**Our Case Number:** ABP-317265-23

**Re: Strategic Infrastructure Development - ABP- 317265 – Construction of ‘Dyrick Hill Windfarm’ comprising 12 no. wind turbines and related work including approximately 16 kilometres of underground cables in the Townlands of Ballymacmague North, Ballymacmague South, Ballynaguilkee Lower, Ballynaguilkee Upper, Broemountain, Carrigaun (Mansfield) and others, Co. Waterford.**

Uisce Éireann has reviewed the information submitted as part of this Strategic Infrastructure Development and has the following observations:

Drawing file: 11. Planning Drawing Schedule and Planning Drawings / 05829-DR-154_110kV Trench Service Over Crossing.pdf

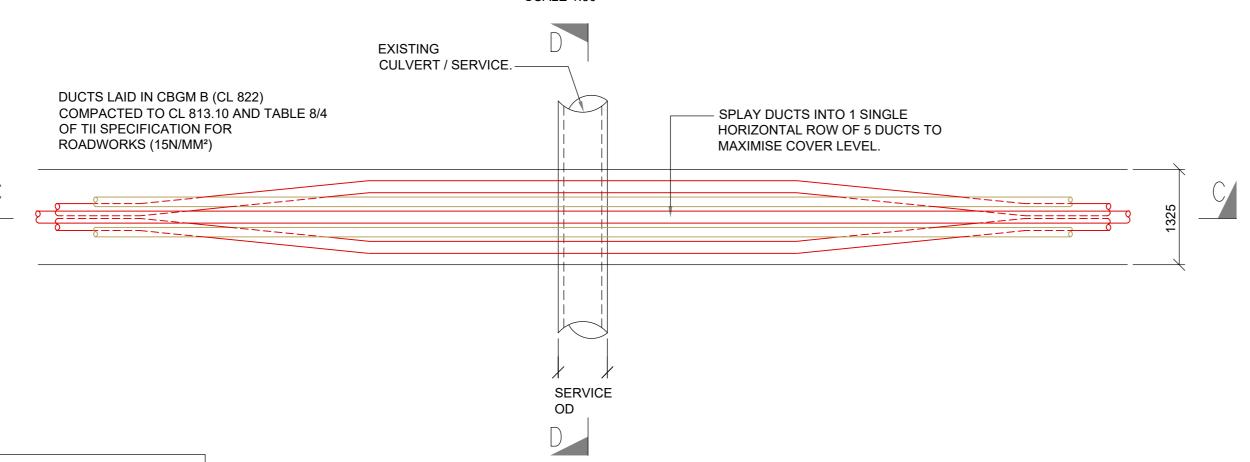
Uisce Éireann notes that the applicant's proposals for the 110 kV underground cable has the potential to cross above Uisce Éireann assets at a number of locations points. To date no details have been provided to Uisce Éireann for these potential locations points. The applicant needs to advise on where the crossing points of Uisce Éireann assets are by providing details that include the Irish Grid Co-ordinates, the Uisce Éireann Asset Types at all locations and the Uisce Éireann Asset Material/Diameter at each crossing point.

Uisce Éireann cannot support any proposals to cross above our assets without sufficient, clear and detailed information to provide evidence that no impact to Uisce Éireann's assets will arise as a result of the cabling works undertaken.

If the applicant has demonstrated that no other option is feasible but to cross above Uisce Éireann assets, then the applicant must propose appropriate and adequate mitigation measures as part of their design proposal to ensure that:

- a) no additional load is applied to Uisce Éireann assets from above;
- b) it will be possible to access and easily replace the Uisce Éireann assets in the locations under the 110 kV underground cable in the future;
- c) no impact to Uisce Éireann's assets will arise as a result of the cabling works undertaken;
- d) agree the detailed design for the crossings above with Uisce Éireann and enter into an associated Build Over Agreement.

1. The applicant shall demonstrate where no other option is feasible but to cross above Uisce Éireann assets when laying the 110 kV underground cable at any of the potential location that need to be identified.
2. Where it is demonstrated by the applicant that no other option exists but to cross above Uisce Éireann assets, the applicant shall provide to Uisce Éireann;
  - a. updated designs demonstrating how their proposals mitigate any impact to Uisce Éireann's assets;
  - b. updated designs demonstrating no additional load is applied to Uisce Éireann assets from above and;
  - c. proposals demonstrating how it will be made possible for Uisce Éireann to access, maintain and easily replace the Uisce Éireann assets in the locations under the 110 kV underground cable in the future.
